DECISION DELEGATED TO DEVELOPMENT MANAGER

Application No: H13-0130-20 **Applicant:** Mr M Ogunade
Proposal: Front porch extension, garage conversion and creation of rear dormer
Location: 7 Benton Close Moulton Chapel Spalding
Terminal Date: 20th October 2020

Notes:
 All dimensions to be checked on site by the contractor prior to setting out or fabrication of components.
 The contractor is not to scale dimensions off this drawing.
 No measuring survey carried out by TAD Studio.
 This drawing shall not be reproduced without written authority.

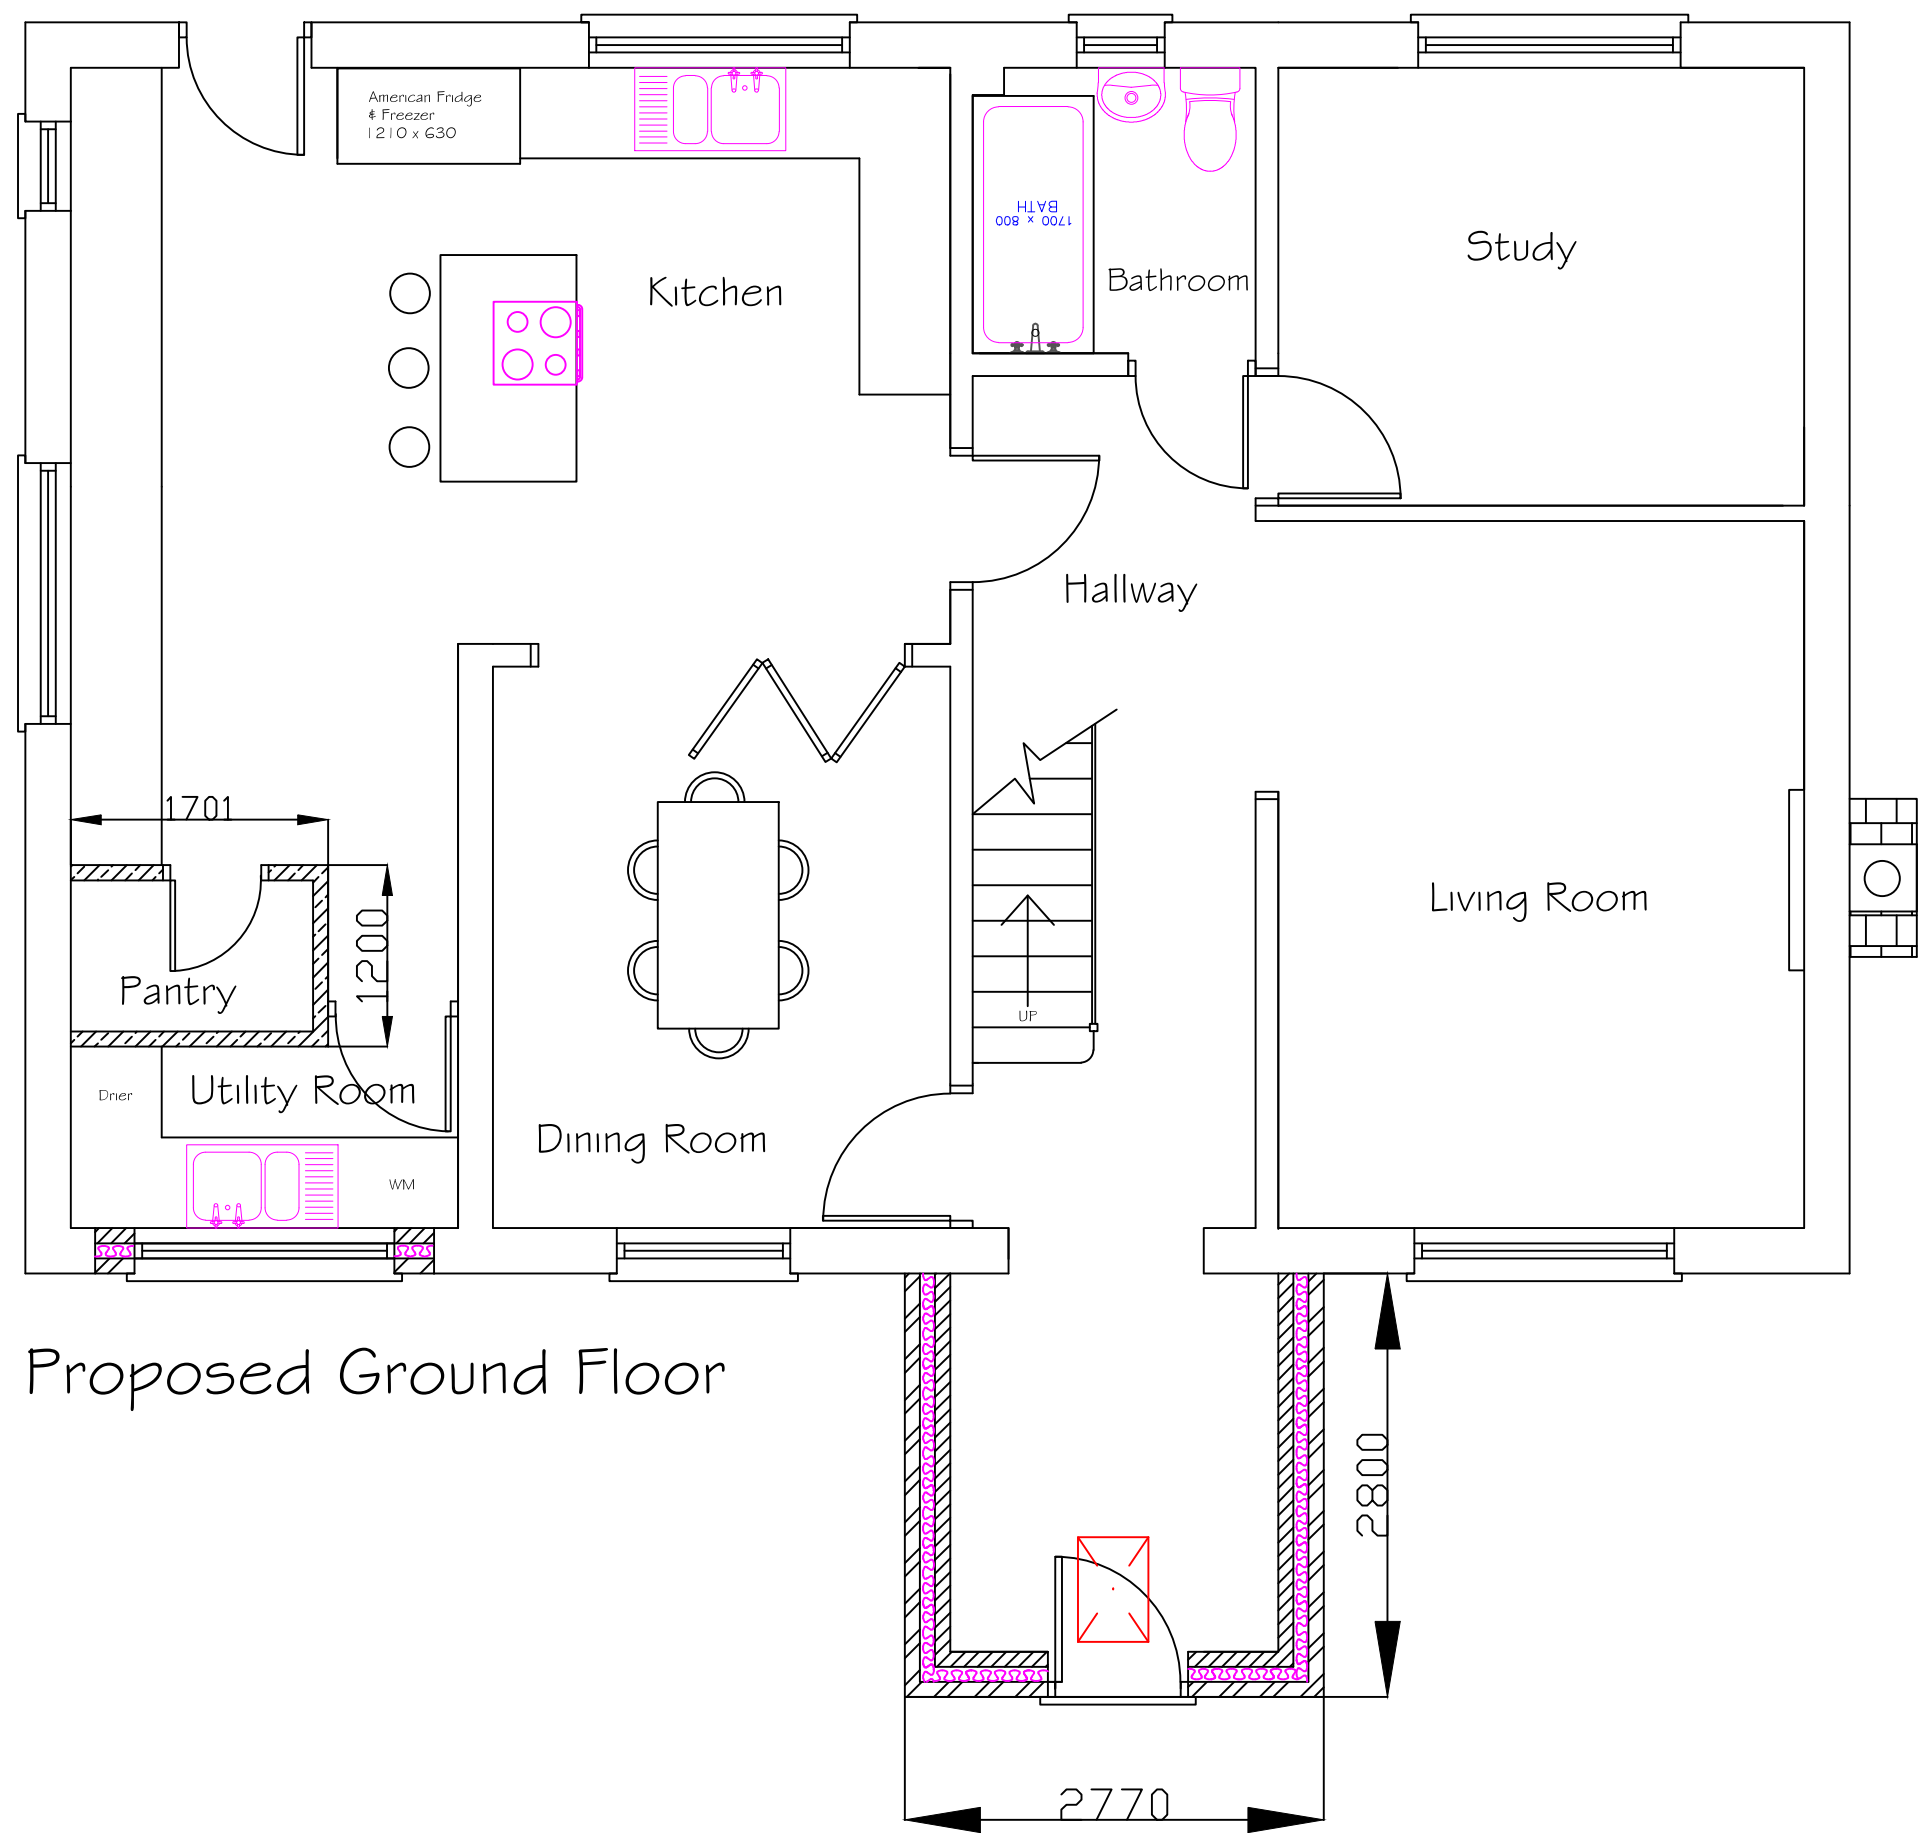
The initial plans proposed a box shaped dormer including four windows. After following discussions

The front porch will be bricked in all external elevations. A hip roof will be on top of the porch which will provide further variety to the mixture of gable pitches on front dormer windows and shed roof on the rear dormer. Formerly, the proposals include a box style rear dormer. The revised plans have replaced the flat roof for a shed roof which will avoid an eyesore and contribute to soften the sharpness of the form of development and, ultimately, deliver a high quality designed loft conversion.

with the agent, revised plans were submitted showing a shed roofed dormer. The number of four windows remains.
